Appeal Decisions

Decision date: 02 June 2021

Appeal A Ref: APP/Z4718/W/20/3263293 57 Underbank Old Road, Holmfirth HD9 1AS

Appeal B Ref: APP/Z4718/Y/21/3268691 57 Underbank Old Road, Holmfirth HD9 1AS

1 Proposed Site Plan

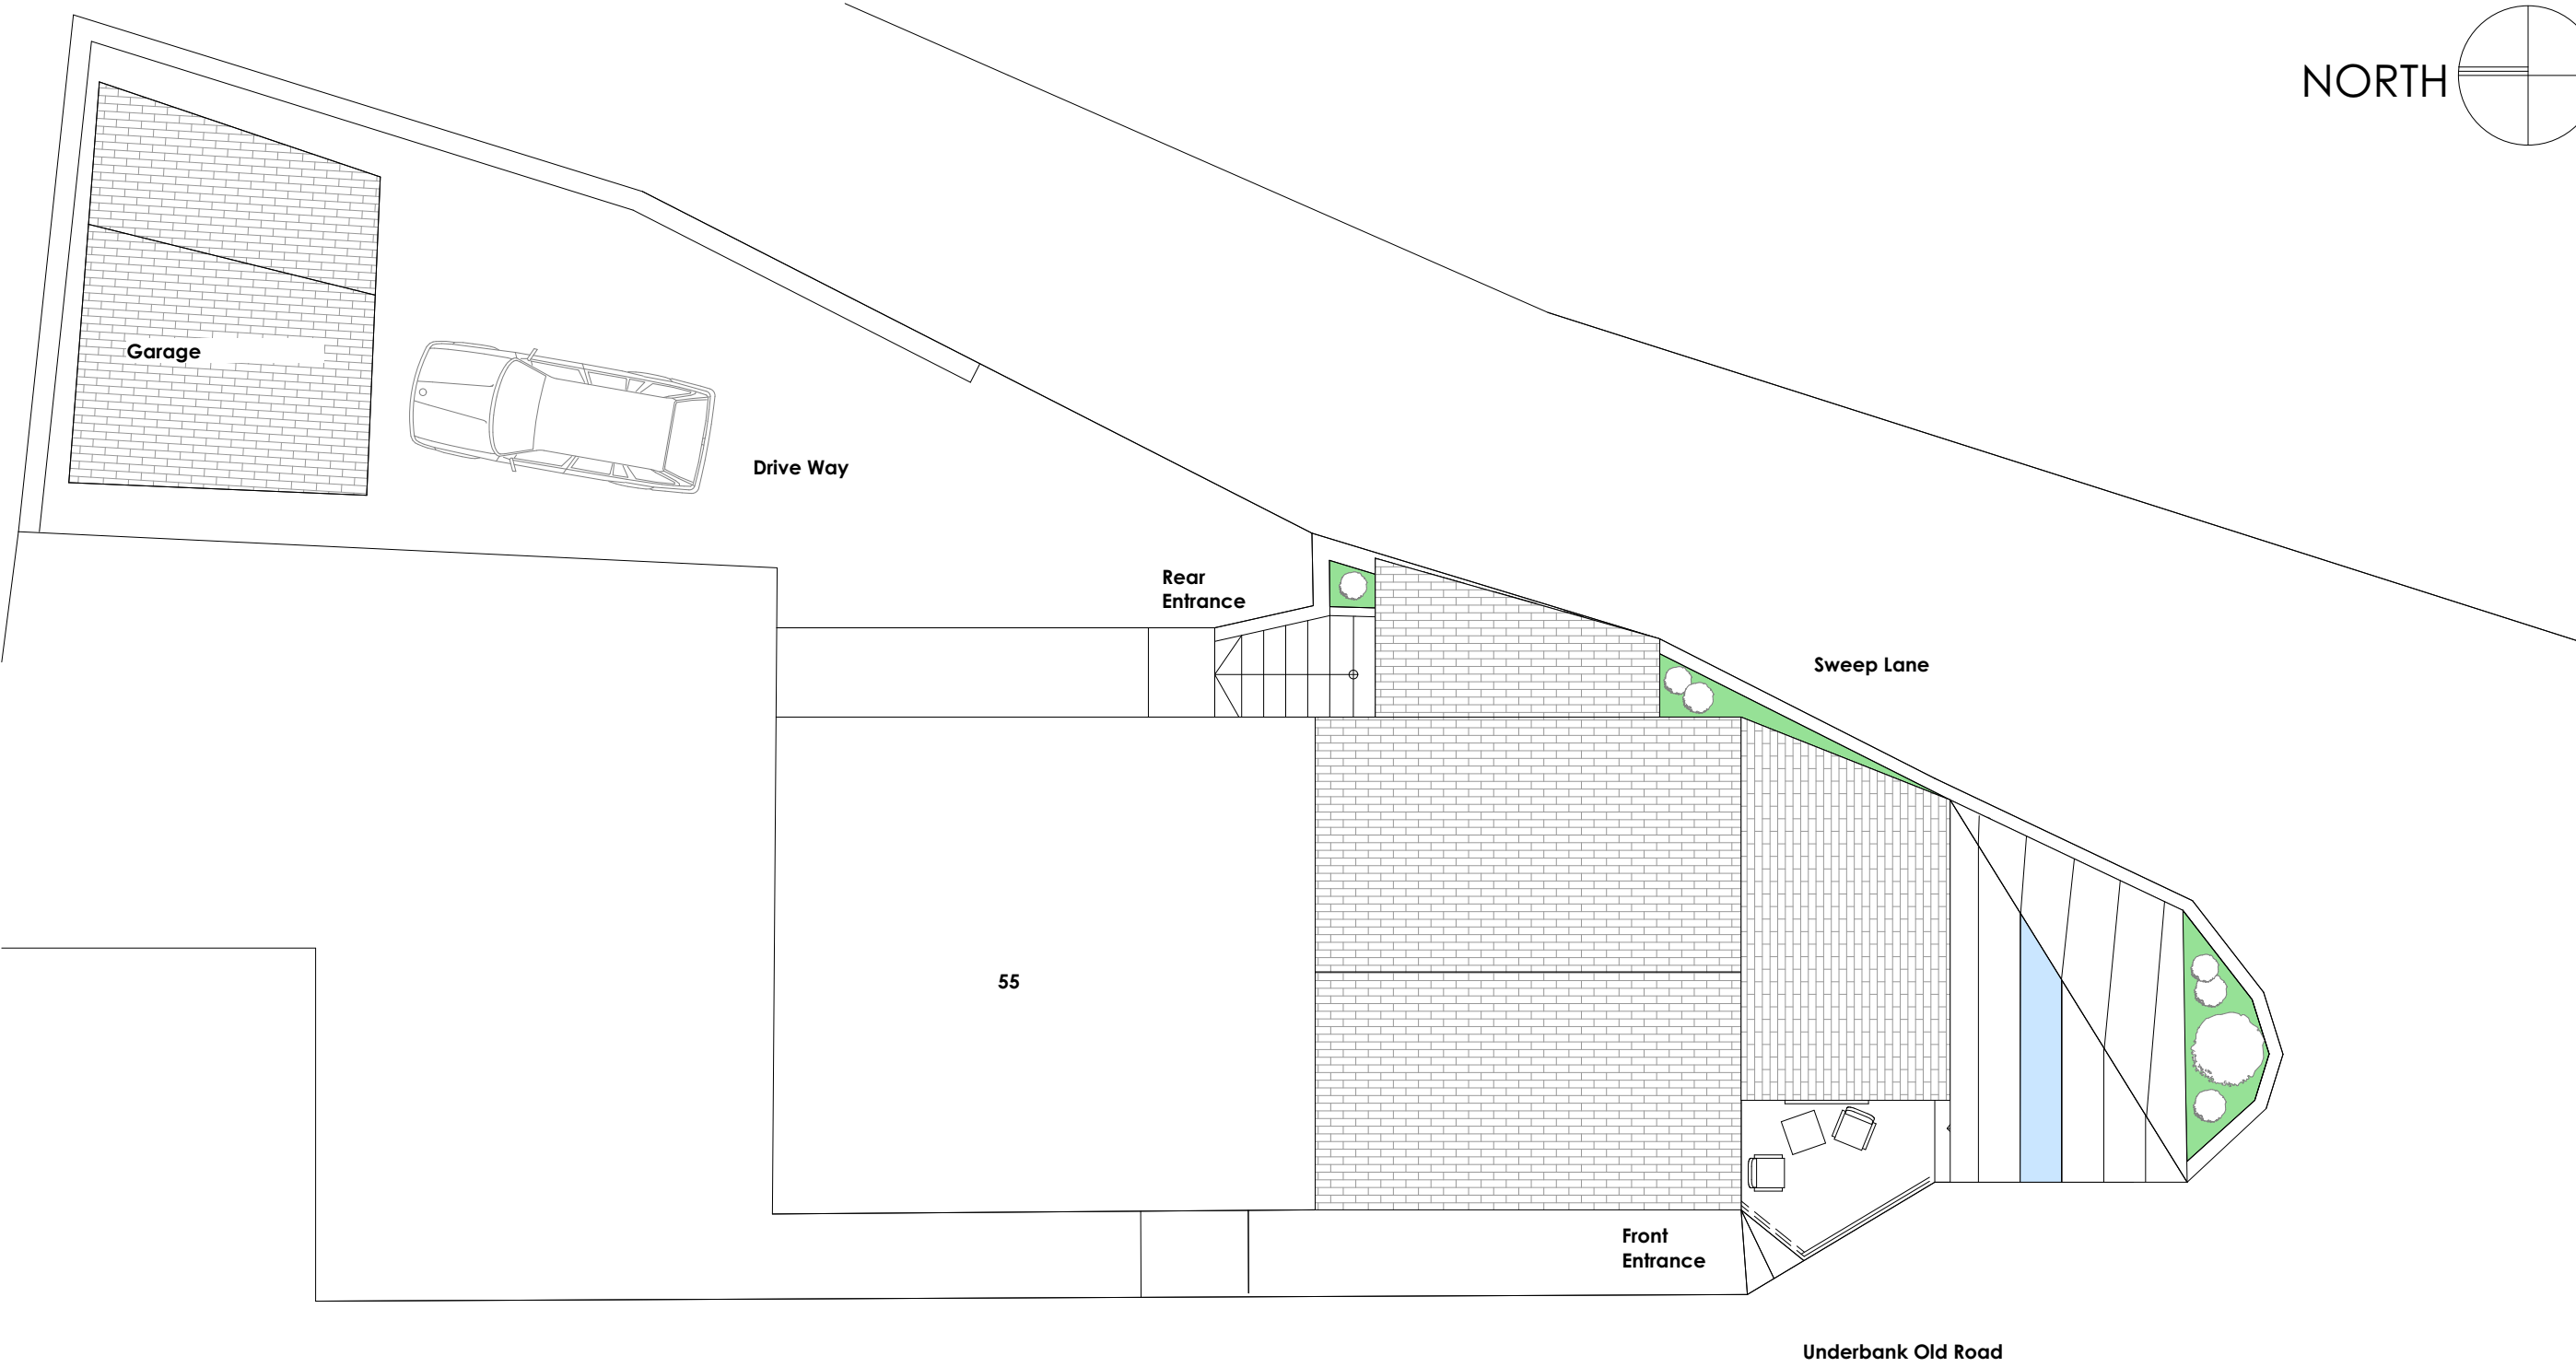
10. The proposal comprises a single-storey lean-to extension, adjoining the later two-storey extension to the main element of the property. The proposed extension would project south, over the existing private amenity space at the side, tapering to fit the shape of the space. It would also have a smaller element projecting west and fronting Underbank Old Road. The extension would be constructed of stone with a stone slate roof, with a three-light stone mullion window in the west elevation. A large window would be located in the

south elevation and some of the submitted drawings show rooflights incorporated into the roof pitch. The proposal would also include the repurposing of the rear drive and garage as a rear garden and summer house.

12. Nevertheless, the proposal would introduce additional built form to the southern side of the property, resulting in the building's incremental extension and horizontal elongation. This would severely weaken the dwelling's strong and characteristic vertical emphasis. Moreover, the minimal set back of the extension's western projection from the main front building line of the house and the inclusion of three-light stone mullioned windows, would cause it to compete for prominence with the primary building and disrupt the architectural hierarchy of the property.

25. The proposal would result in the loss of the existing private amenity space located immediately adjacent to the south of the house and accessed via a door from the kitchen in the southern elevation of the later extension.

26. However, it would also involve the creation of a garden area along with a summerhouse at the rear of the property in place of the existing garage. I accept that this space is not immediately adjacent to the house or historically associated with the property. Nevertheless, it is within the bounded confines of the house's curtilage and its distance from the rear entrance is not unduly excessive, nor is the route to it arduous or unsafe. Furthermore, there would also be a small courtyard area immediately in front of the house which would be only slightly smaller than the existing private amenity space available.
